Bassetlaw District Council  
Planning Department  
Queen's Buildings  
Potter Street  
Worksop  
S80 2AH

### OBJECTION

**Application Ref: 22/01109/FUL, High Ridge, Top Street, Askham, NG22 0RP**

north facing elevation

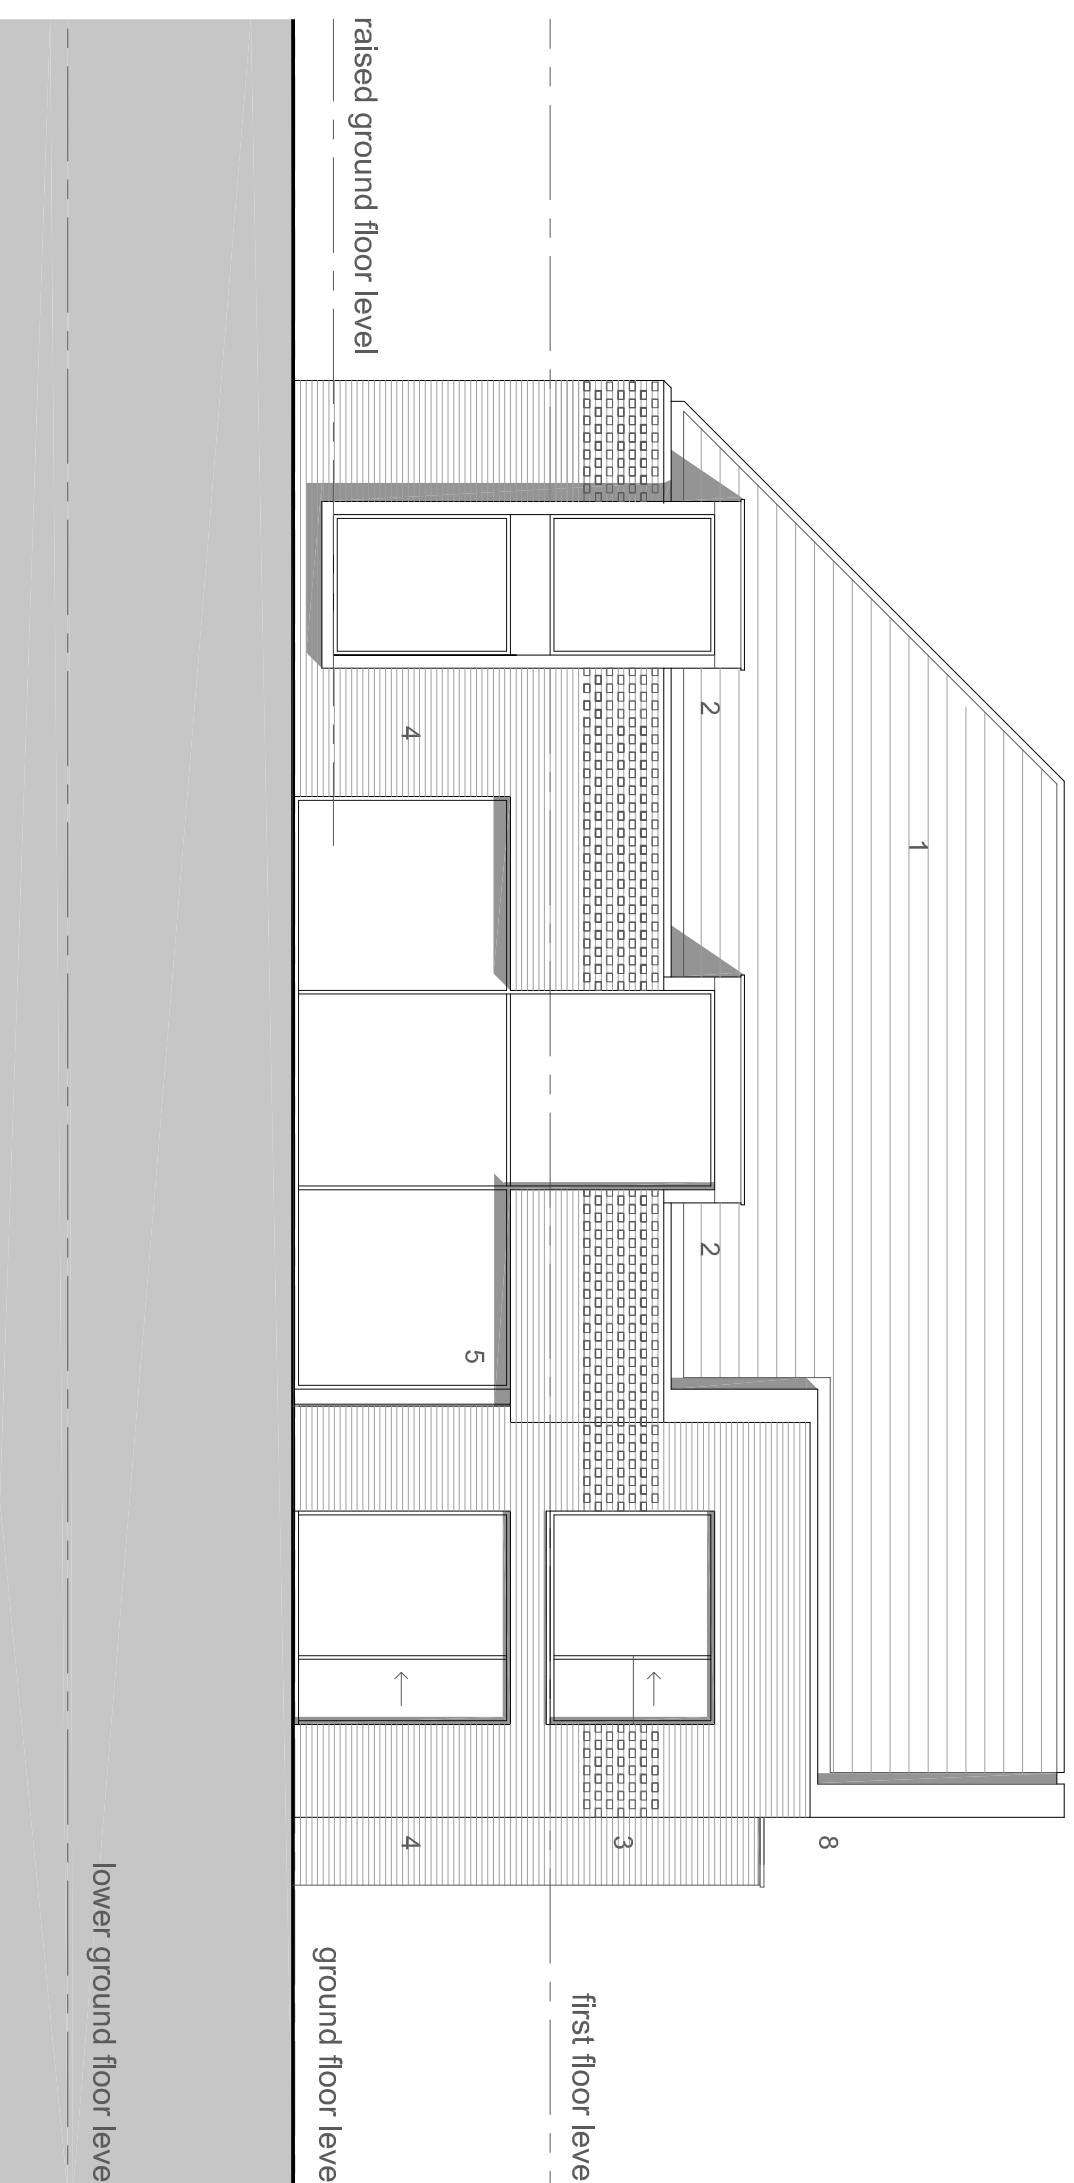
The materials proposed are of high quality, intended to reflect the local architecture and there are details which can be seen in local buildings. The scale of the development and the proportions of glass and brick do not relate to local character. This amounts to a pastiche. A large modern building has had some design elements from local architecture included without altering the fact that it is a massive construction using large areas of glass.

Height and Massing study in relation to neighbouring houses

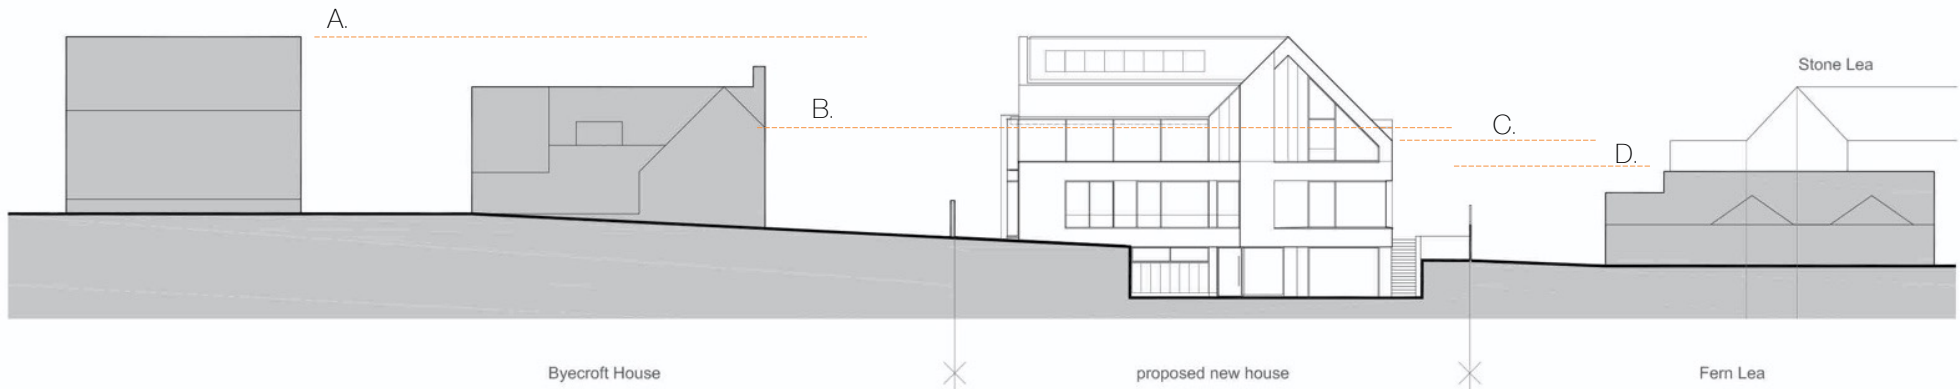
The proposed build is out of scale with the neighbouring properties. The design of three storeys requires a ridge height that has been aligned with that of the house at the top of the hill. The natural fall in the land of Top Street is currently followed by the roof lines. This natural and pleasing line can clearly be seen from our bedroom window. The

higher ridge line of the proposal does not take into account the local topography. In fact there is no proper topographical analysis. Viewed from our direction there will be a jarring effect in the ridge lines, this will be much greater when viewed from the front. Page 9 of the Parish Presentation 13.09.22 clearly shows how the new house dominates, and is out of scale with Byecroft House, itself quite a large building. The buildings further down are smaller and therefore even more overpowered.
